CITY OF PORTLAND

BUILDING PERMIT

Job ID: 2011-06-1304-SF

has permission to Finish 3rd Floor Renovations, Two Family Dwelling Unit.

PROPOSED STAIRCASE : Rise = $7\frac{5}{8}$ "
SCALE $\frac{1}{2}$ " = 1'-0" Run = 10" ($11\frac{1}{4}$ " Tread)

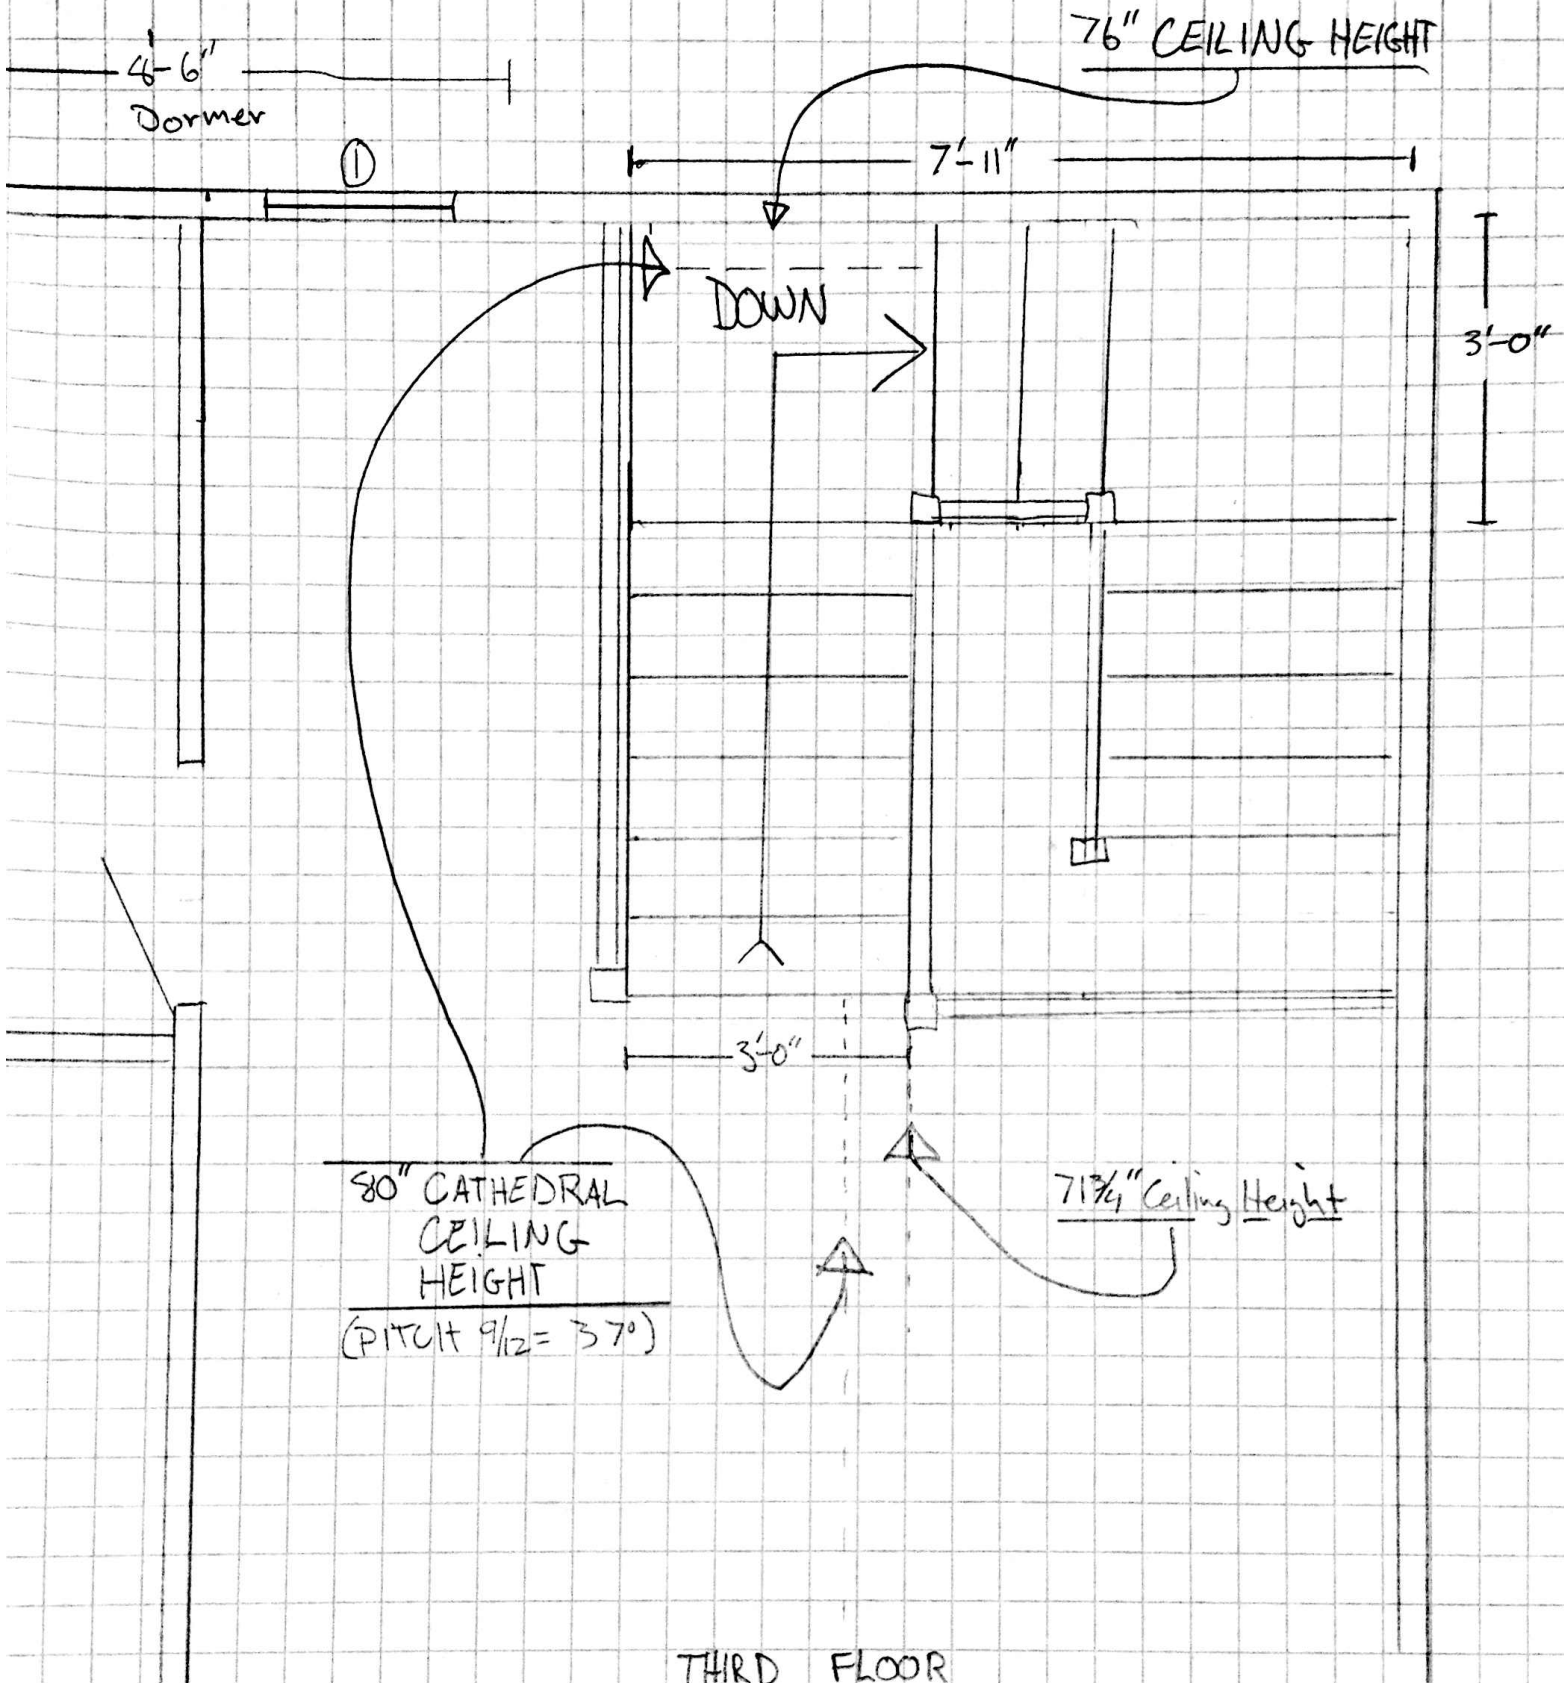
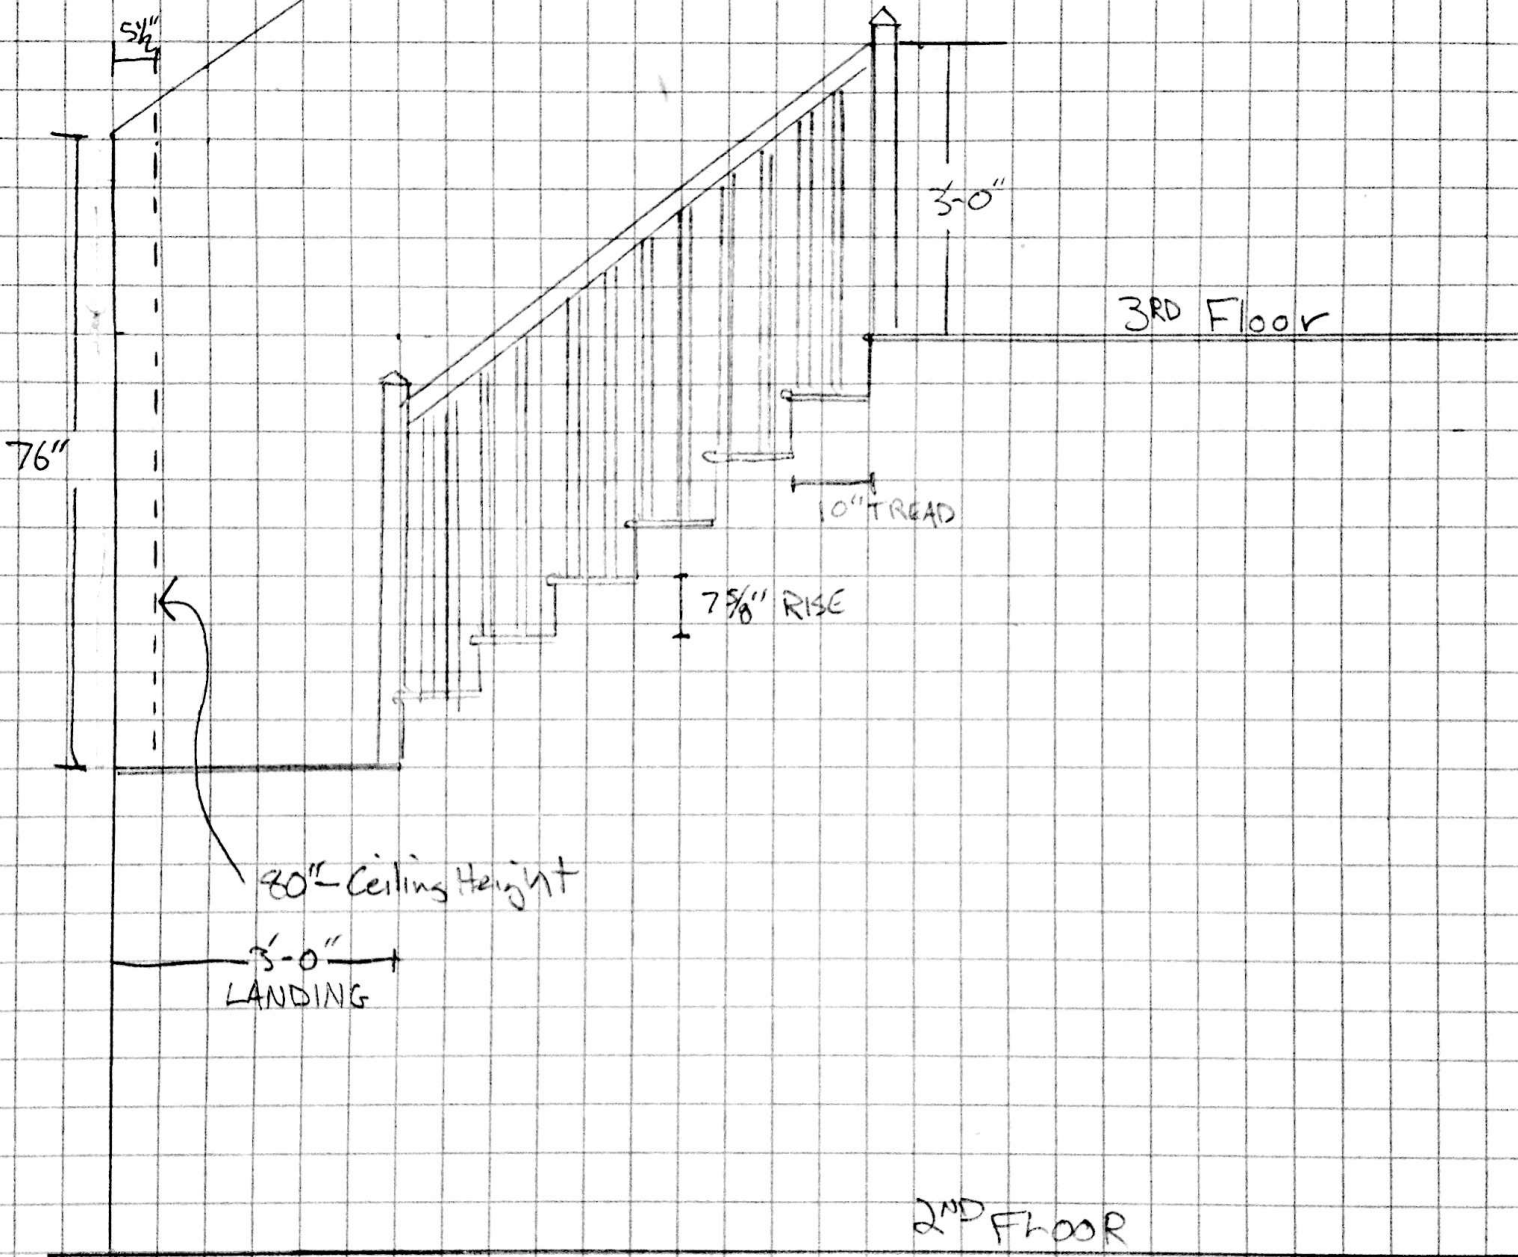
3. A graspable handrail (34-38 inches in height) shall be provided on at least one side of each continuous run of treads or flight with four or more risers. Fall protection (36 inches) from exterior decks may be required if floor joist are at or above thirty (30) inches from grade.

THIRD FLR PLAN
SCALE 3/16" = 1'-0"

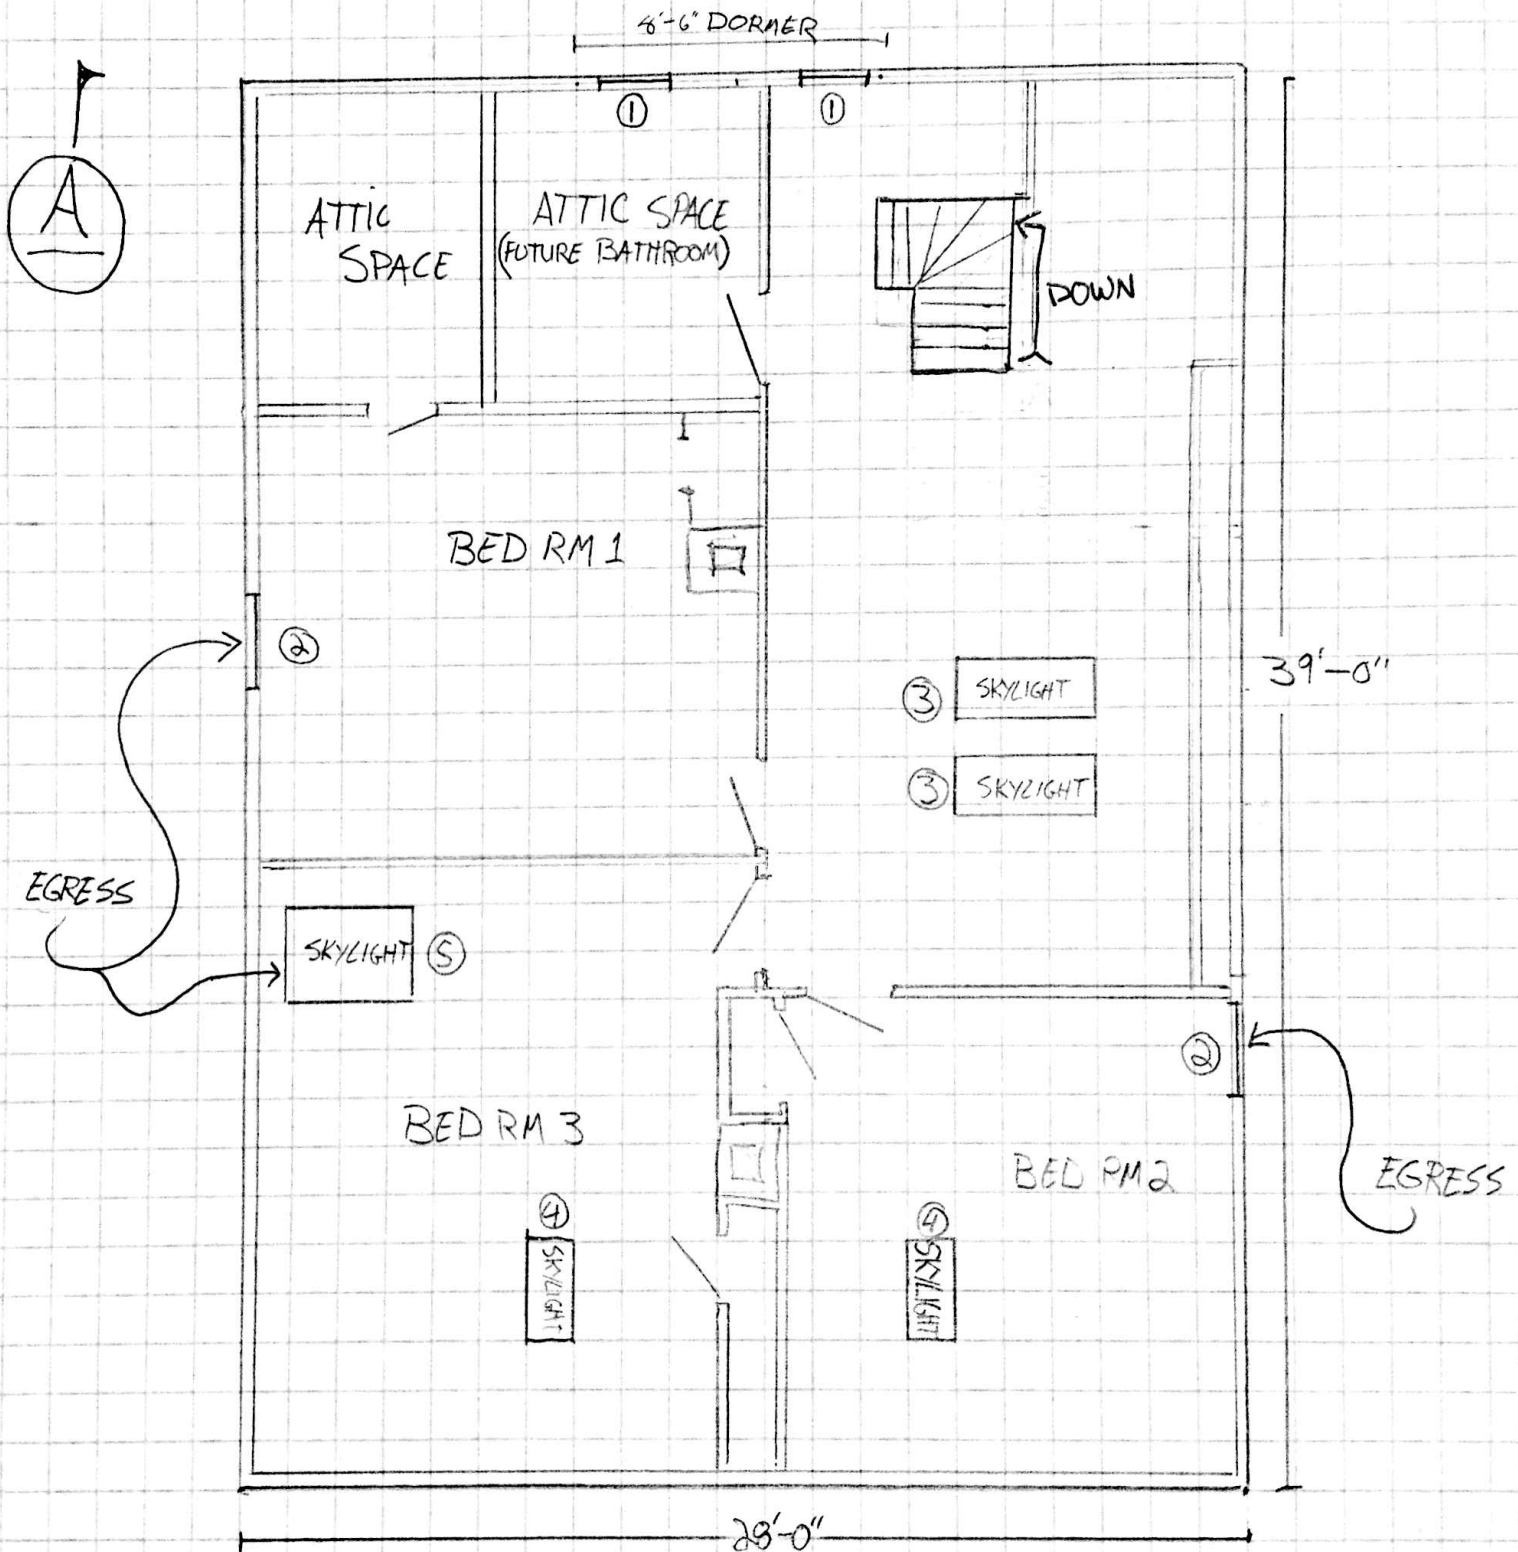
1. Window sills in locations more than 72 inches from finished grade shall be a minimum of 24 inches above the finished floor of the room, unless a window fall prevention devices is installed in accordance with section R612.3.

2. A code compliant emergency escape shall be provided in the bedroom. Window sills in locations more than 72 inches from finished grade shall be a minimum of 24 inches (no higher than 44 inches) above the finished floor of the room.

5. A photoelectric Carbon Monoxide (CO) detector shall be installed in each area within or giving access to bedrooms. That detection must be powered by the electrical service (plug-in or hardwired) in the building and battery.

6. Hardwired photoelectric interconnected battery backup smoke detectors shall be installed in all bedrooms, protecting the bedrooms, and on every level.
